Re: Development at Root Farm, Dunsop Bridge,
Variation of condition approval ref 3/2023/0817

Please find enclosed on behalf of the Duchy of Lancaster, a non material alteration application to cover some minor amendments to 7 No approved window / door openings to the “L” shaped building forming small workshop units within the central courtyard to Root Farm.

Client	The Duchy of Lancaster		
Contract	Root Farm Dunsop Bridge		
Drawing title	Proposed amended floor plan detail to L Shaped Building		
Scale	Job No.	Drg No.	D
1:50	HB105	S 09

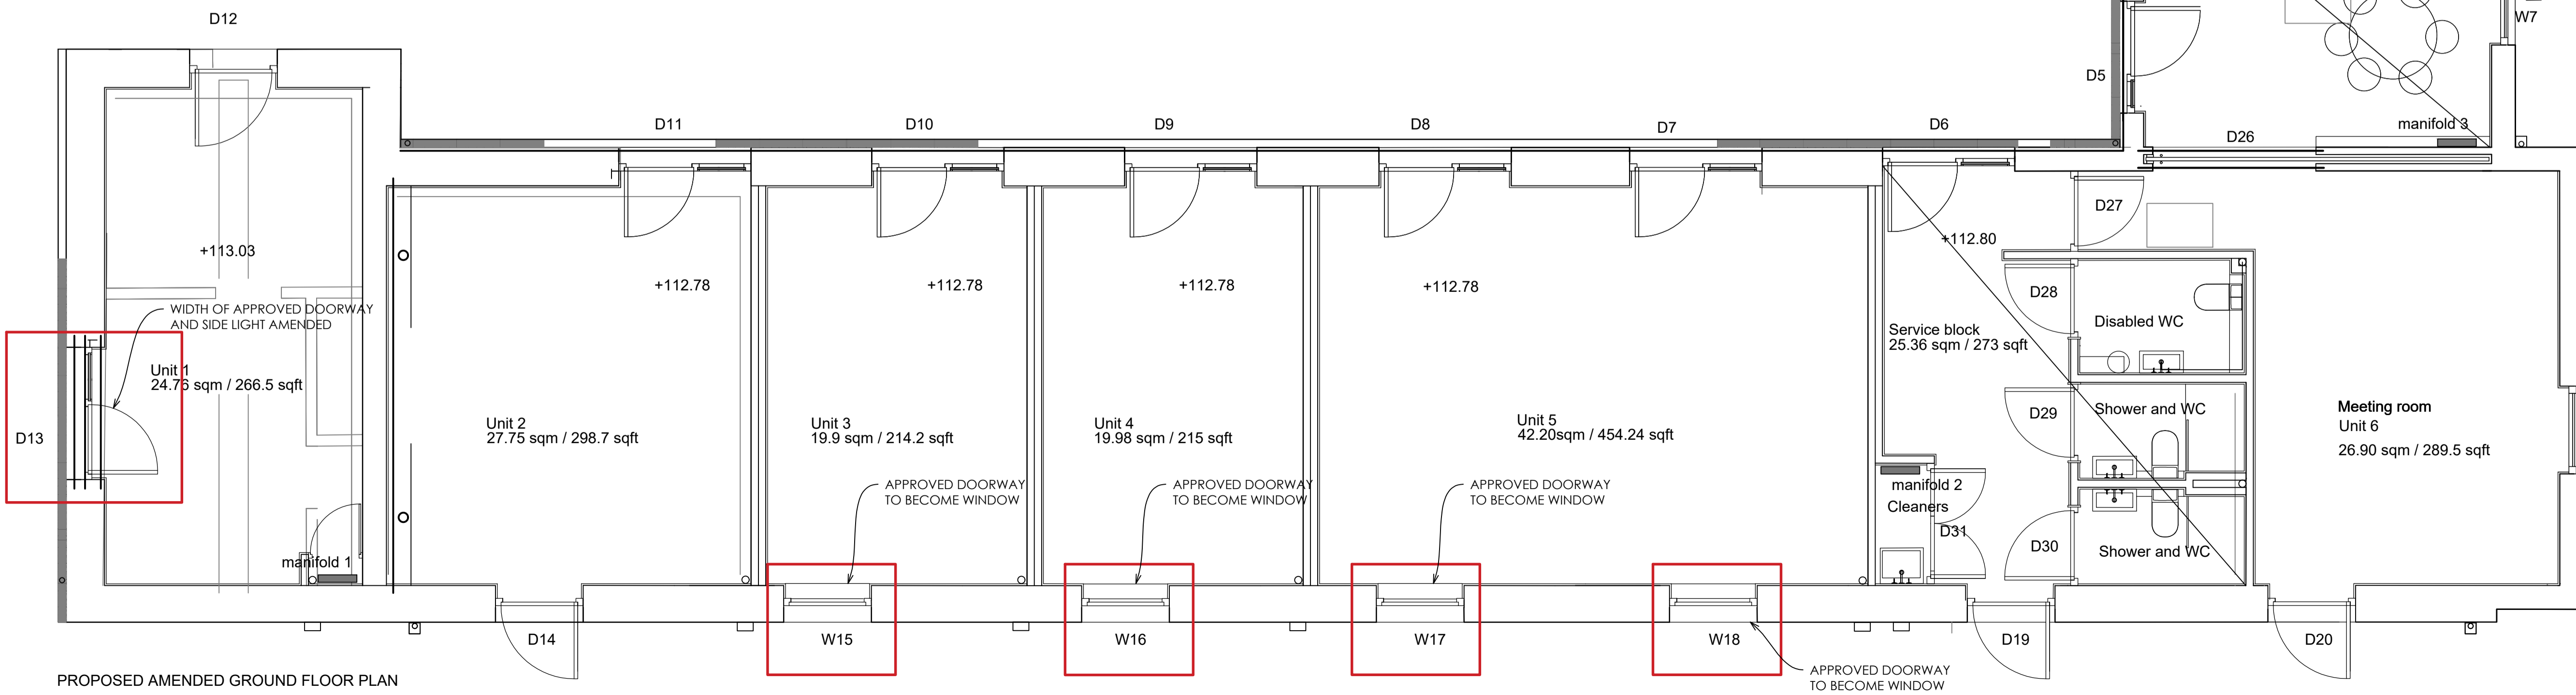
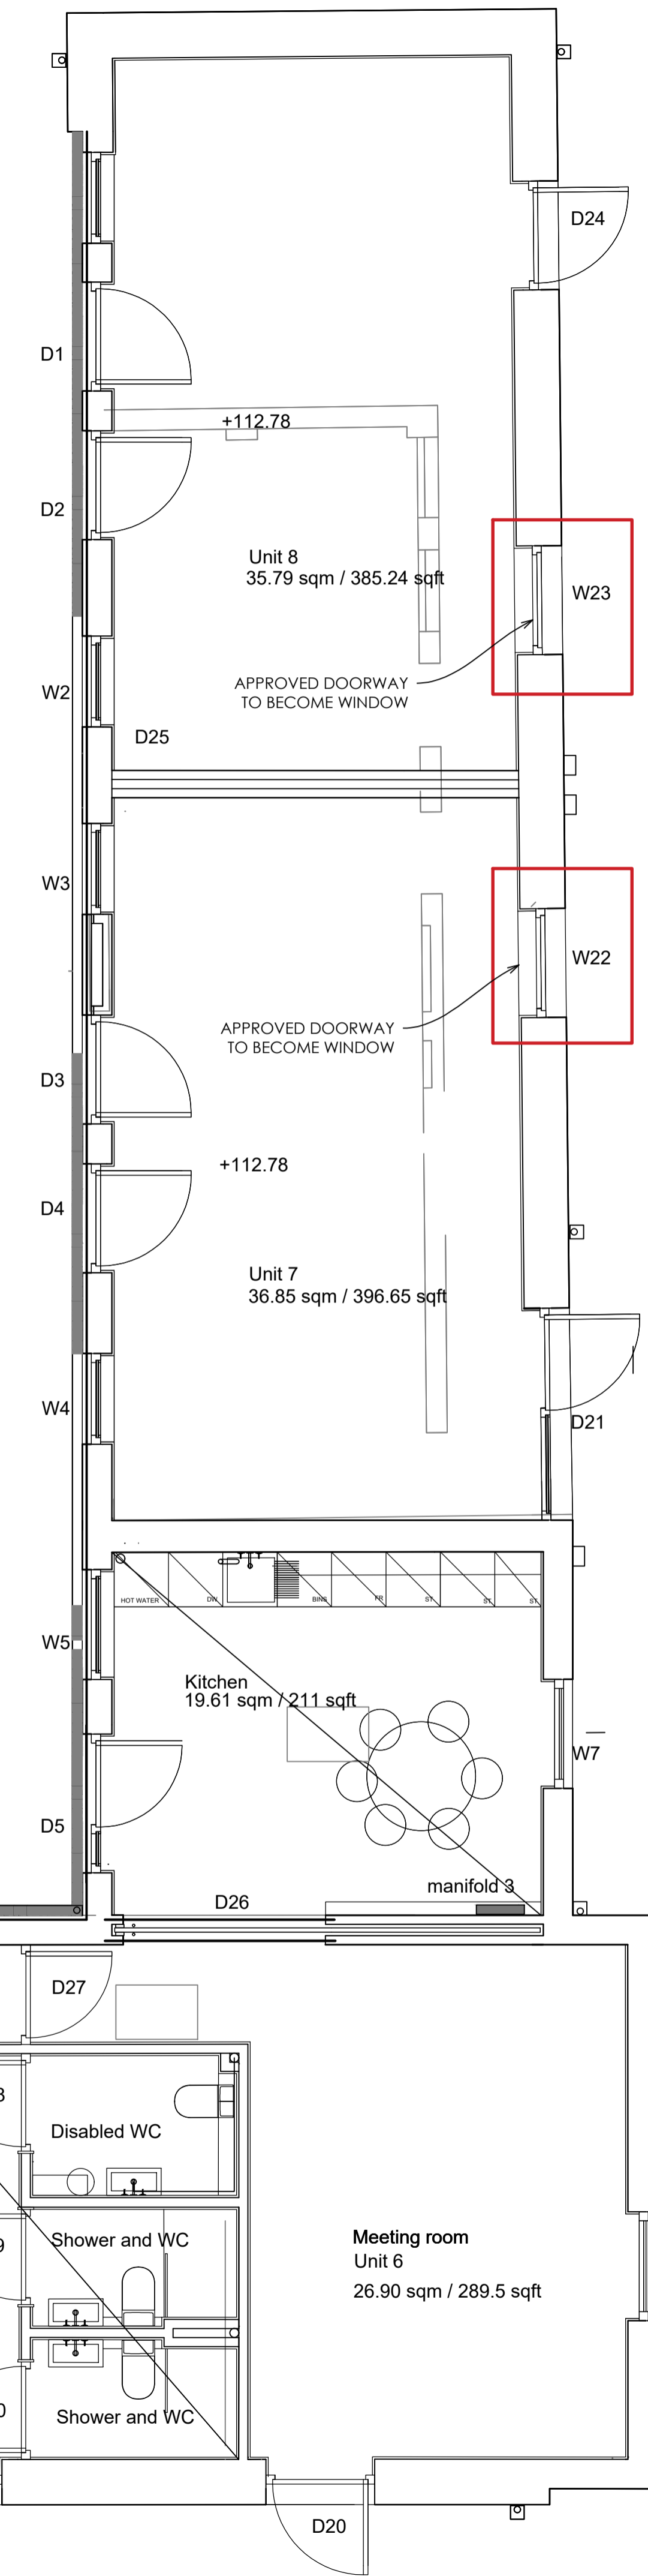
With ongoing design development and changes to the client's brief requirement to ensure the small workshop units are practical, and in the case of D13 – compliant with disabled access, we have made amendments to D13, D15, D16, D17, D18, D22 and D23 and enclose copies of both the current approved details and the proposed amendments. All amended details have been clearly identified within red outlines on both S / 08E and S / 09D, drawings enclosed.

D13 is approved with a fan light split into 6 sections and a central sub division of the door and window below. Unfortunately, as the main entrance to this unit, the doorway is not compliant with Part M building regulation in respect to the clear opening width of the door. As a result, we have amended the detail to sub divide the fan light over into 5 (with better proportion) and then split the door / side window on a 3/2 ratio. All of the original detail remains the same.

D15 – D18 and D22 - D23 are approved as new door openings formed within a mixture of original window openings and two original door positions. Following detailed discussion and looking at the “useable” space to be created within these small units, it has been concluded that additional “rear” doors are surplus to requirement and present an element of security risk. The clients have therefore, asked that to these locations, the doors are replaced with windows (allowing furniture and benching etc to be positioned along the rear workshop walls). As the window detail reflects the original wall detail, we trust that this is an acceptable and straight forward amendment that can be approved.
